The Bourtons Parish Council
Great & Little Bourton, Banbury, Oxfordshire

Dear Mr Neville
Response to planning application 20/02060/F
Change of use : The Stables, Main Street, Great Bourton

# SITE LAYOUT PLAN

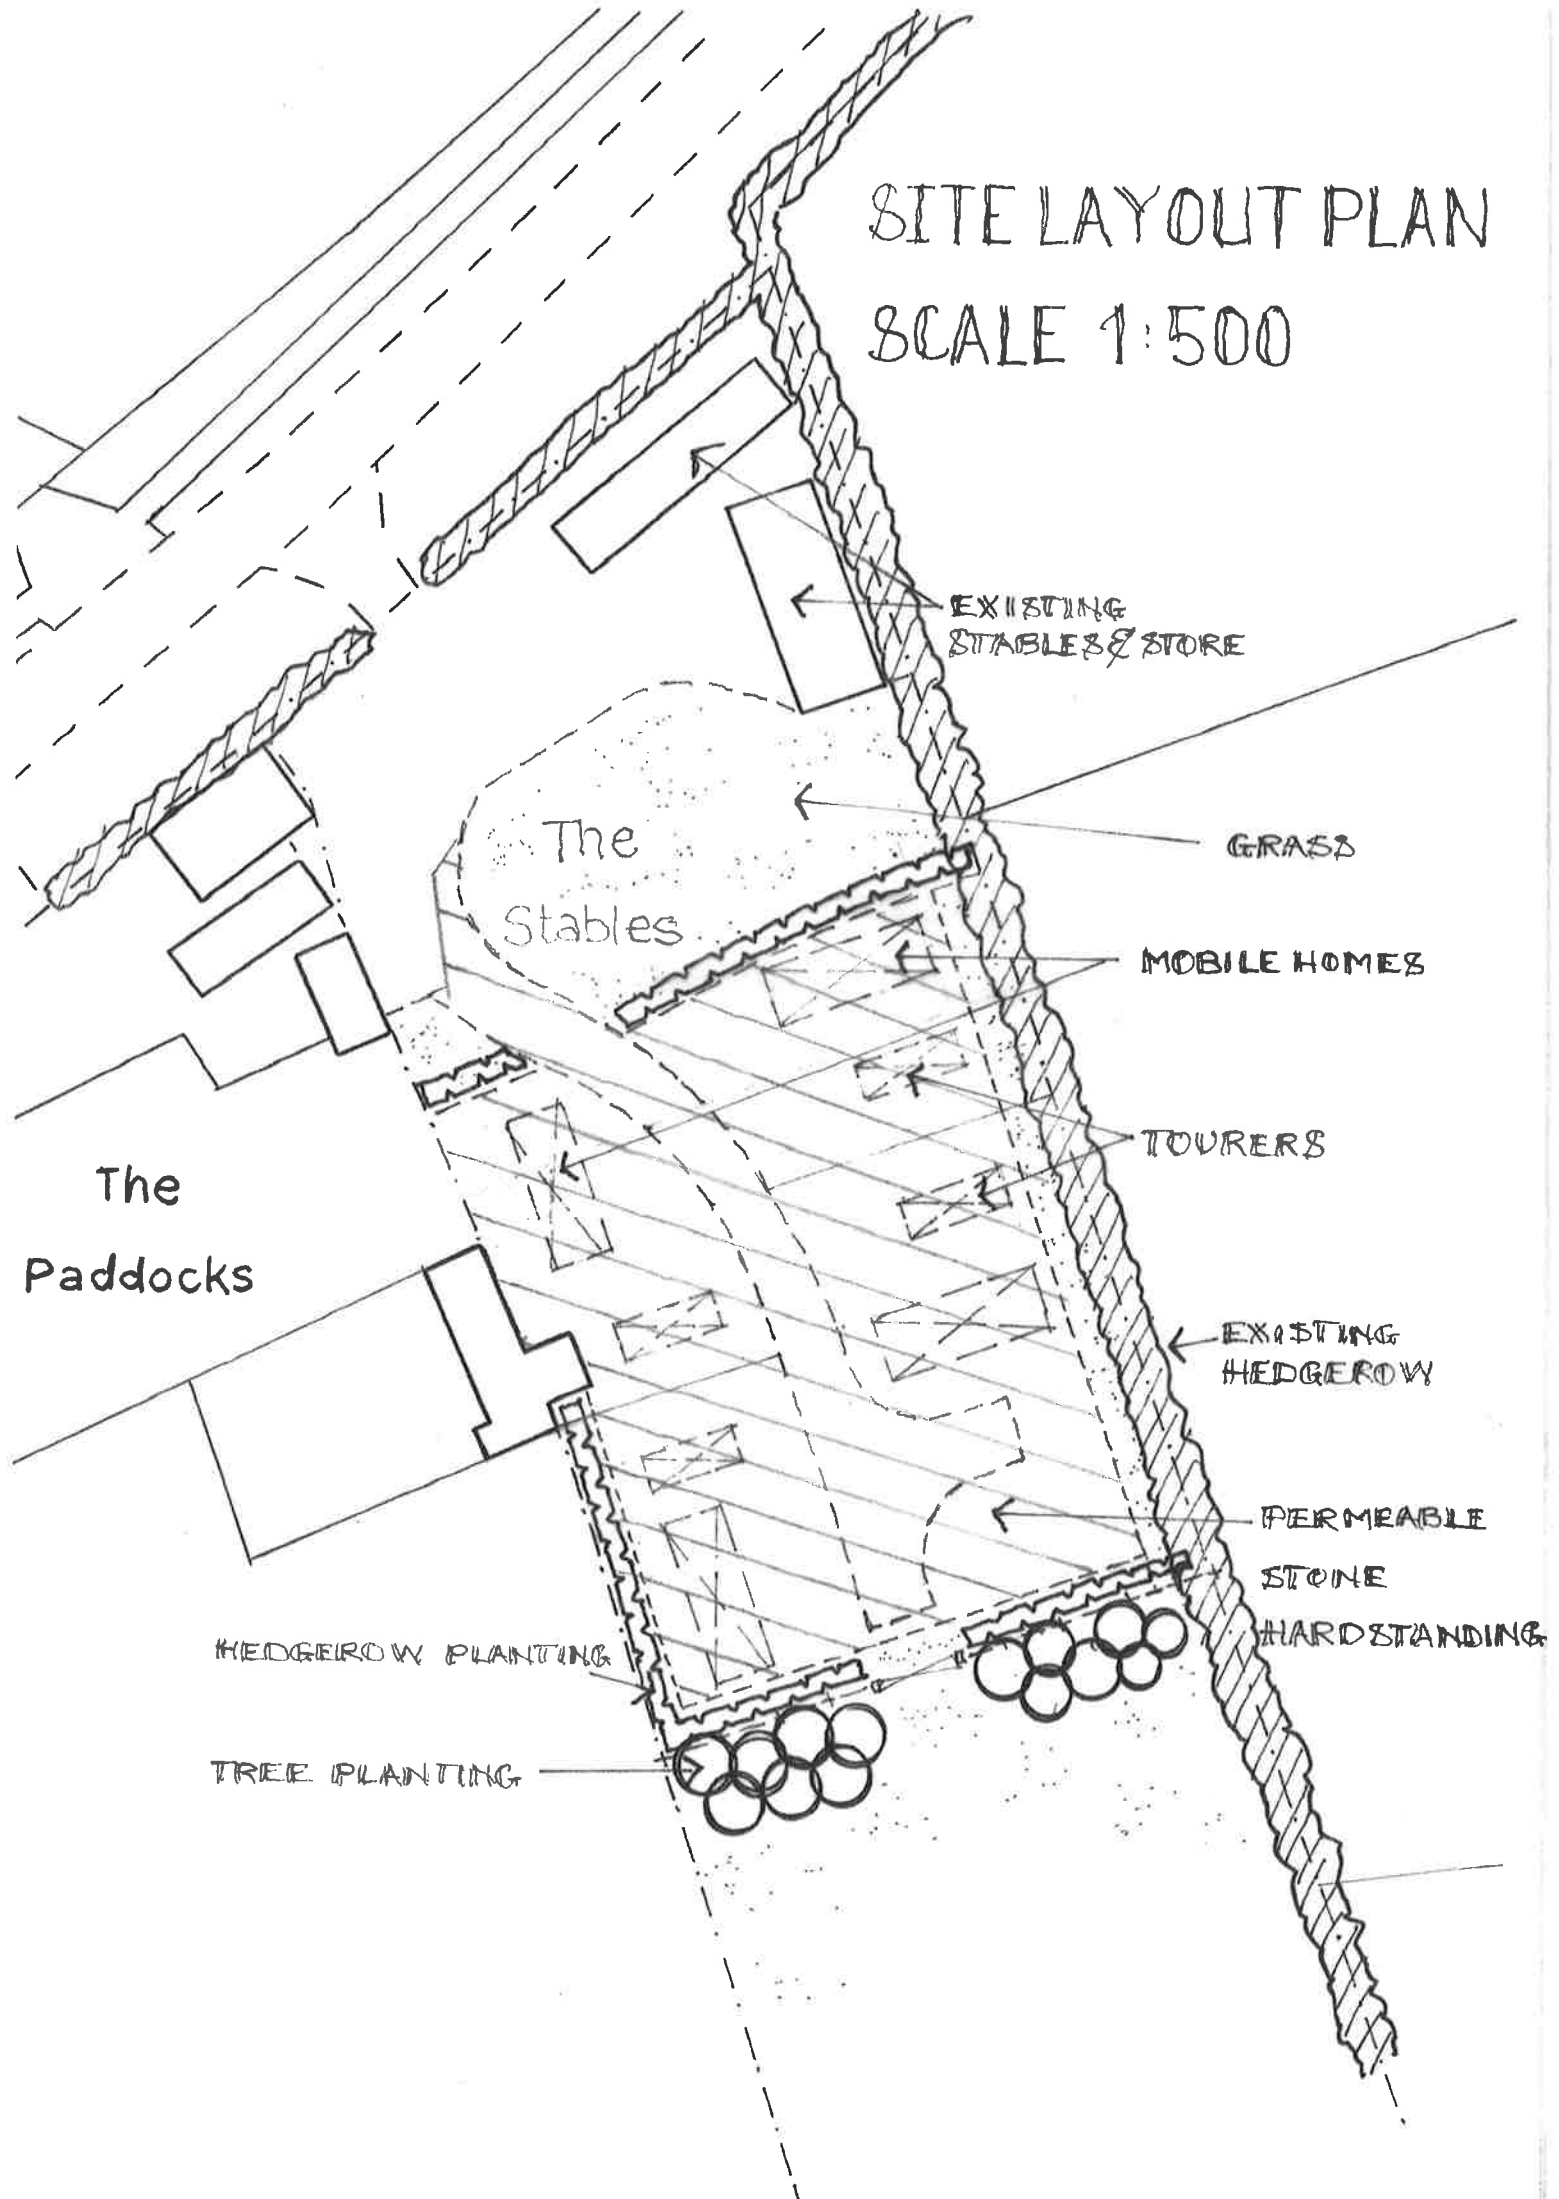
The proposed site is crossed by footpath 138/8 which is not mentioned in the application supporting documents. This path has previously created some concern due to loose dogs causing problems for walkers and OCC Rights of Way officers have already objected to this application on this basis.

No mention is made of any external lighting which is evident on other traveller sites. Since an application has been made for the connection of electricity to the site, we presume that external lighting may be installed but this has not been clarified. External lighting would create a significant visual intrusion into the landscape at night.

The dumping of tons of rubble to create a base for buildings already on this and the adjacent site have blocked the original ridge and furrow drainage scheme causing the annual winter flooding that now occurs. This Council believes that without significant new drainage works the site is unsuitable for residential occupation.

Although the application does mention additional tree planting, we think that a suitable scheme for additional screening planting should be agreed together with a time clause for completion.

The application mentions the provision of a "package sewage treatment plant" but no specific details are provided regarding this, nor the disposal of effluent. Such arrangements should also be agreed with the Environment Agency. As the site drains indirectly into the Sow Burge brook, which runs through the Cropredy School site, located close by, attention is required to ensure that no pollution can occur that could become an environmental threat and place children in the school grounds at risk.
